From: Glenn Gasson [REDACTED]
Sent: 27 September 2021 14:42
To: Simon Davis <Simon.Davis@arun.gov.uk>
Subject: Re: Merry England, Dappers Lane, Angmering - Ref: A/142/16/OUT

From: Simon Davis <Simon.Davis@arun.gov.uk>
Sent: Monday, September 27, 2021 12:12:59 PM
To: Glenn Gasson [REDACTED]
Subject: RE: Merry England, Dappers Lane, Angmering - Ref: A/142/16/OUT

DRAWING TITLE
DRAINAGE LAYOUT

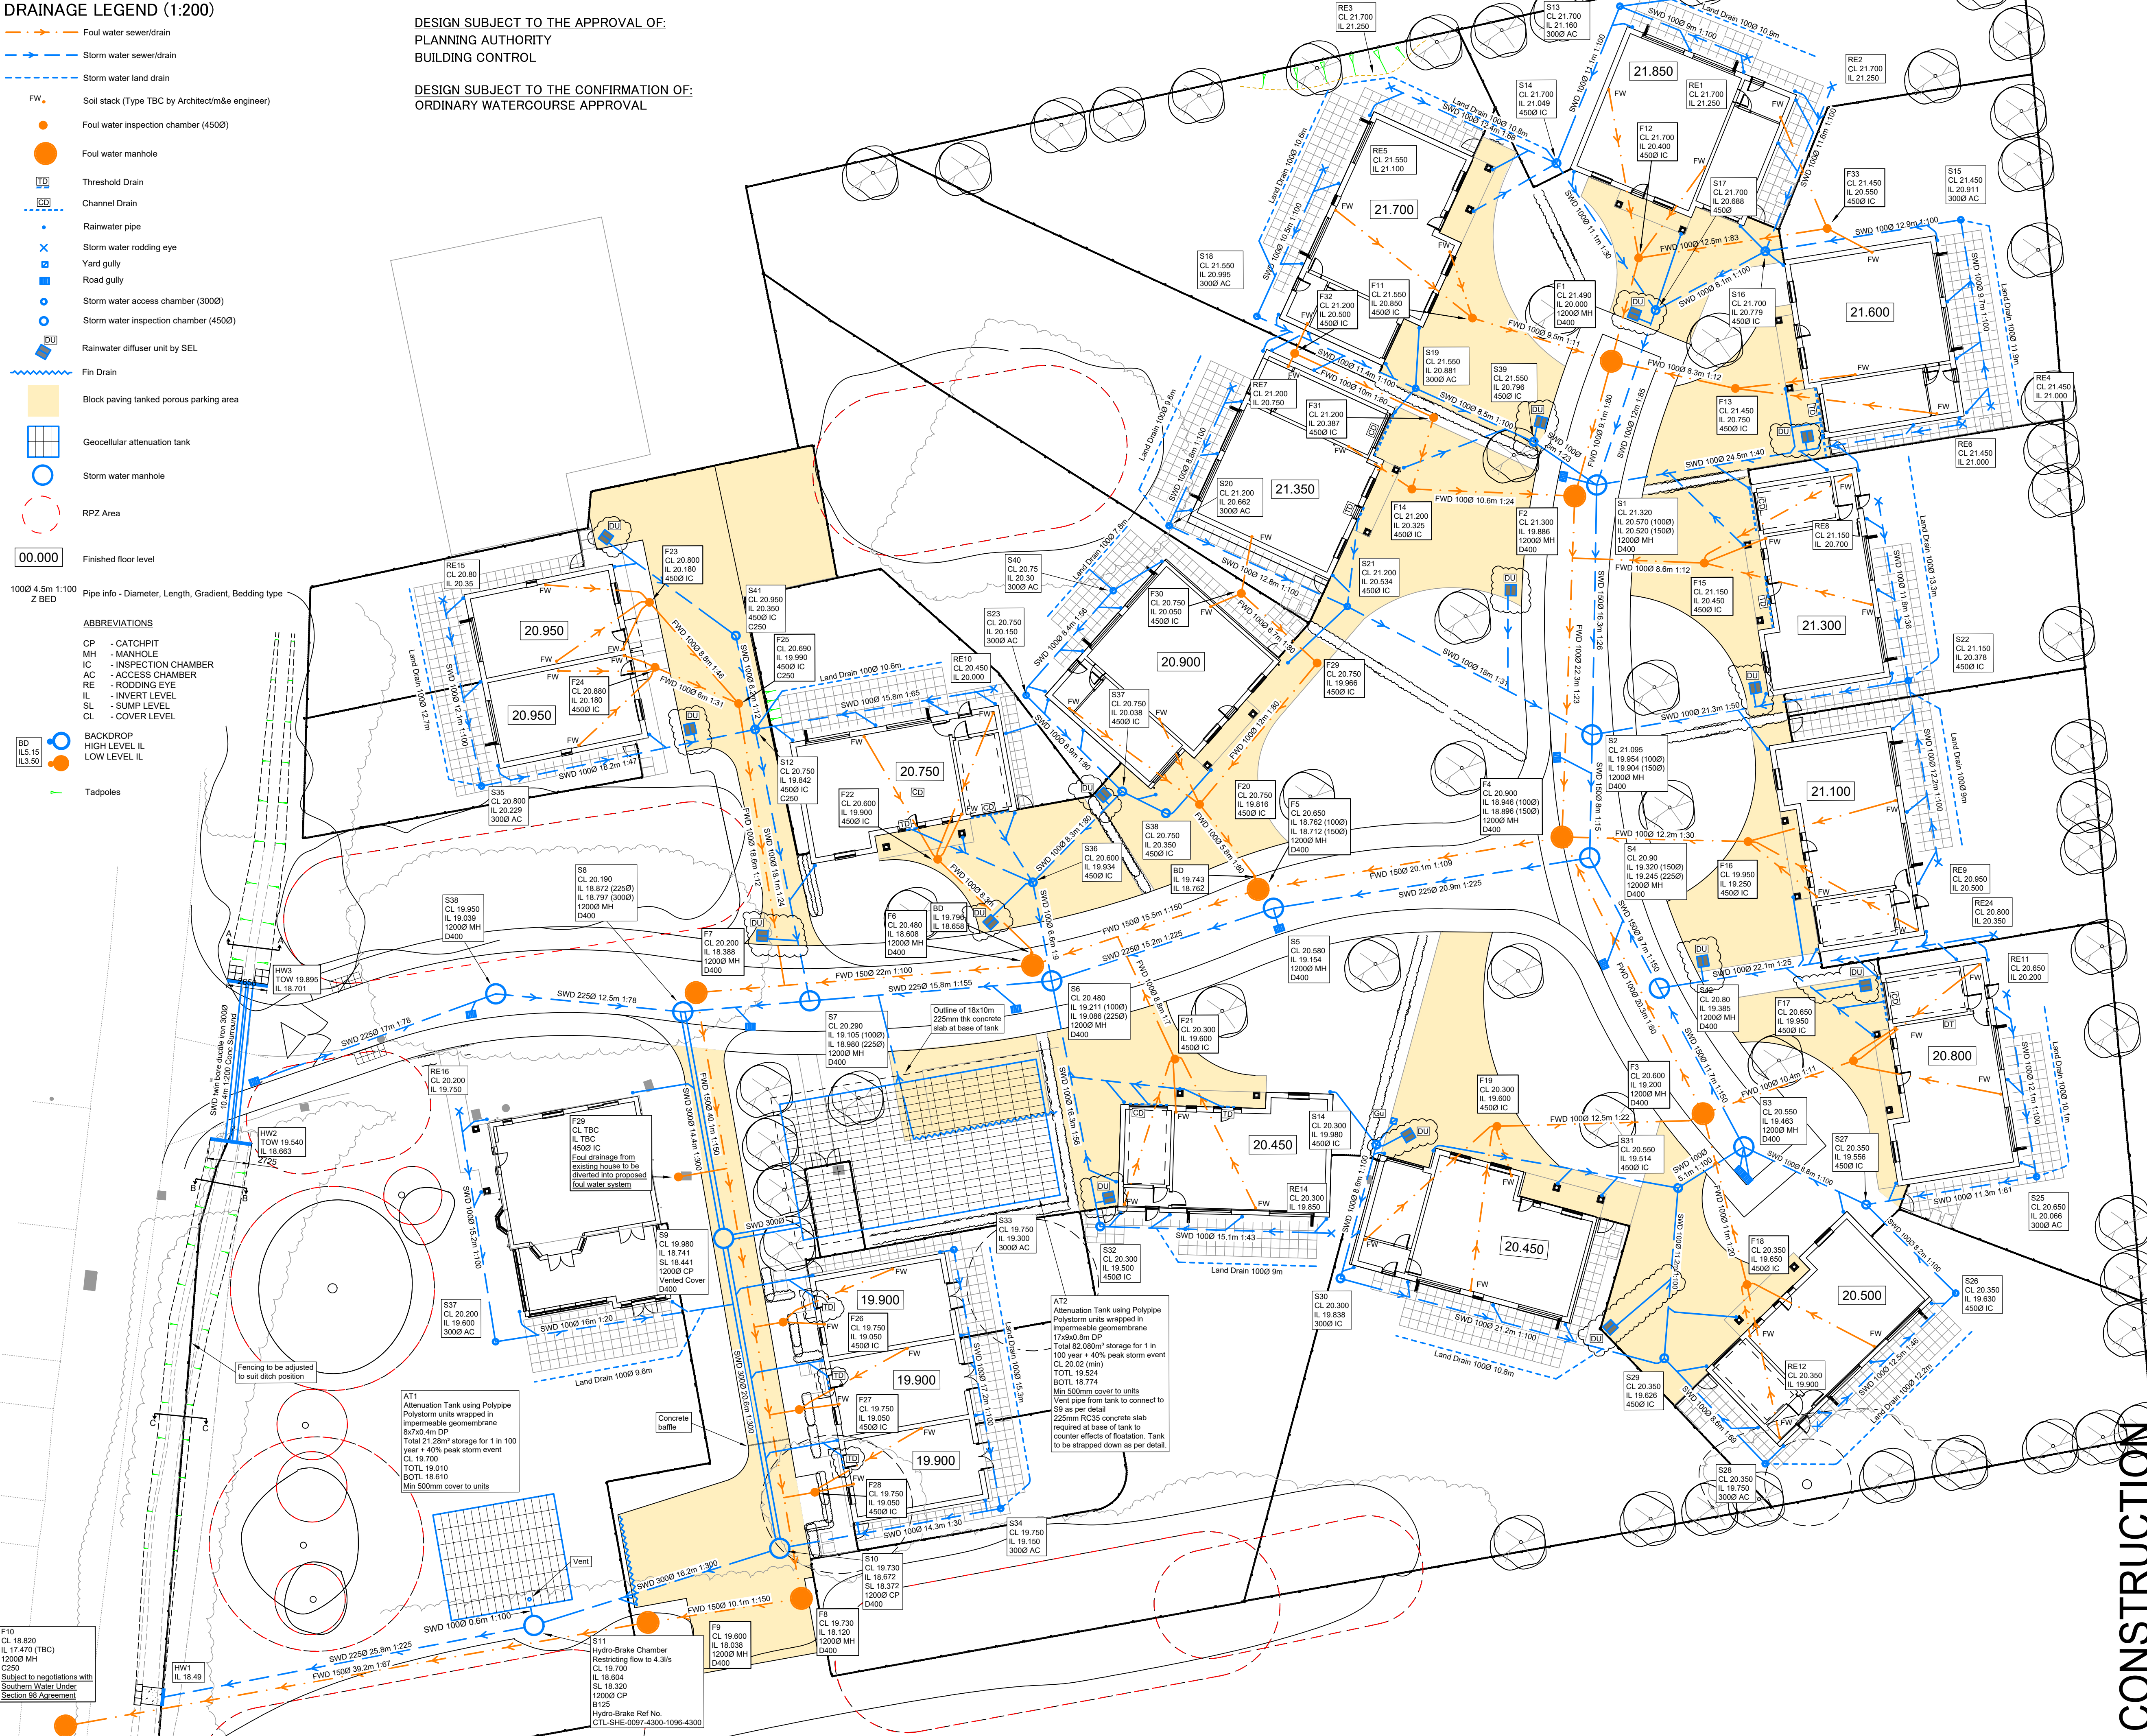
You are seeking to change hardstanding to improve drainage. Whilst I appreciate that this is intended to improve site drainage, we need to consult with our engineers on this as we would be sanctioning a change to the approved drainage plans. Our guidance set out on the website states that we can't do an NMA if it warrants consultation with other Council depts.

I refused something very similar (BR/278/19/NMA) which proposed to change the finishes to parts of the driveway/hardstanding to aid drainage and I stated in response that *we are unable to approve the changes to the hard surfacing, particularly to the driveway as these alter the details approved by BR/193/19/DOC in*

relation to the discharge of condition 07 and it would be necessary to consult with the Councils drainage engineers before such changes could be agreed.

You should instead seek to re-discharge condition 4 of A/91/18/PL. You should also consider whether you need to apply for an NMA of the particular Reserved Matters permission on which hard & soft landscaping details were approved.
